From:
Sent: 06 July 2025 15:05
To: DC Admin
Subject: Objection to Planning Application 2025/91577 – Land Adjacent to 21 Westcliffe Rise

I wish to lodge a formal objection to planning application 2025/91577, concerning the proposed development on the land next to 21 Westcliffe Rise.

SITE PLAN
1:250

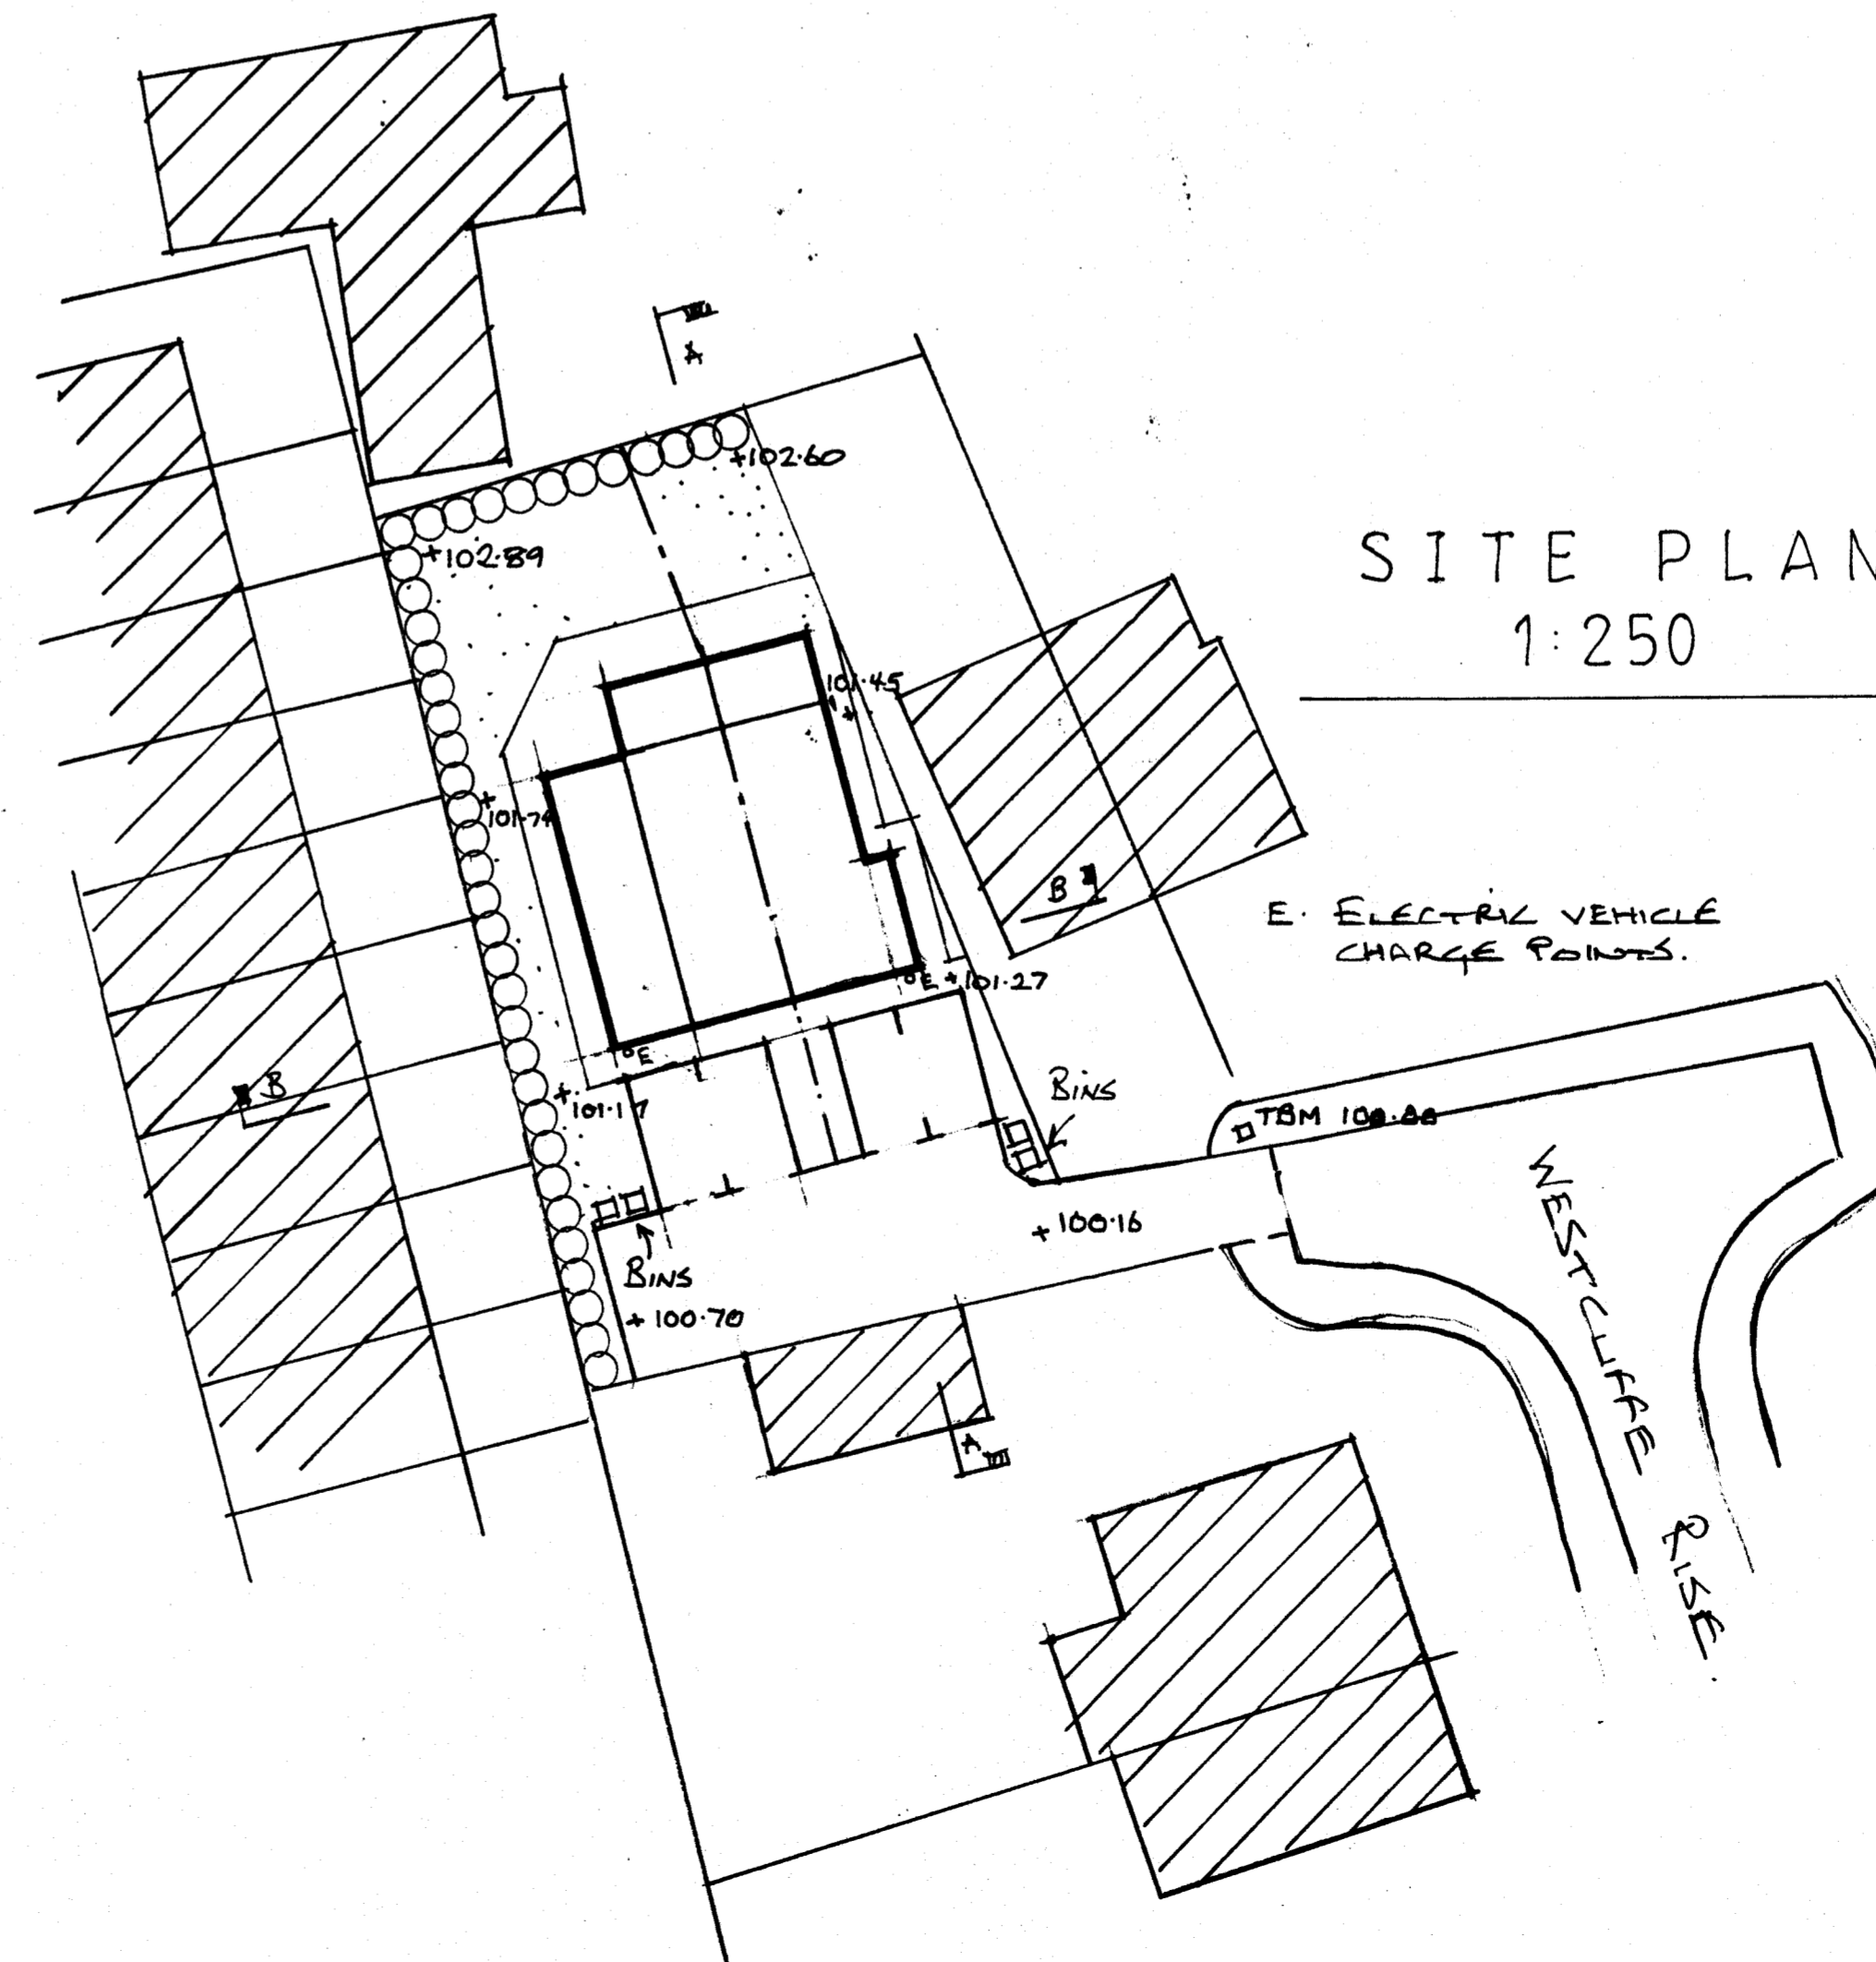
- The new houses are longer than the earlier approval, meaning that our already north-facing garden will receive even less sunlight - negatively affecting amenity and enjoyment of our outdoor space.
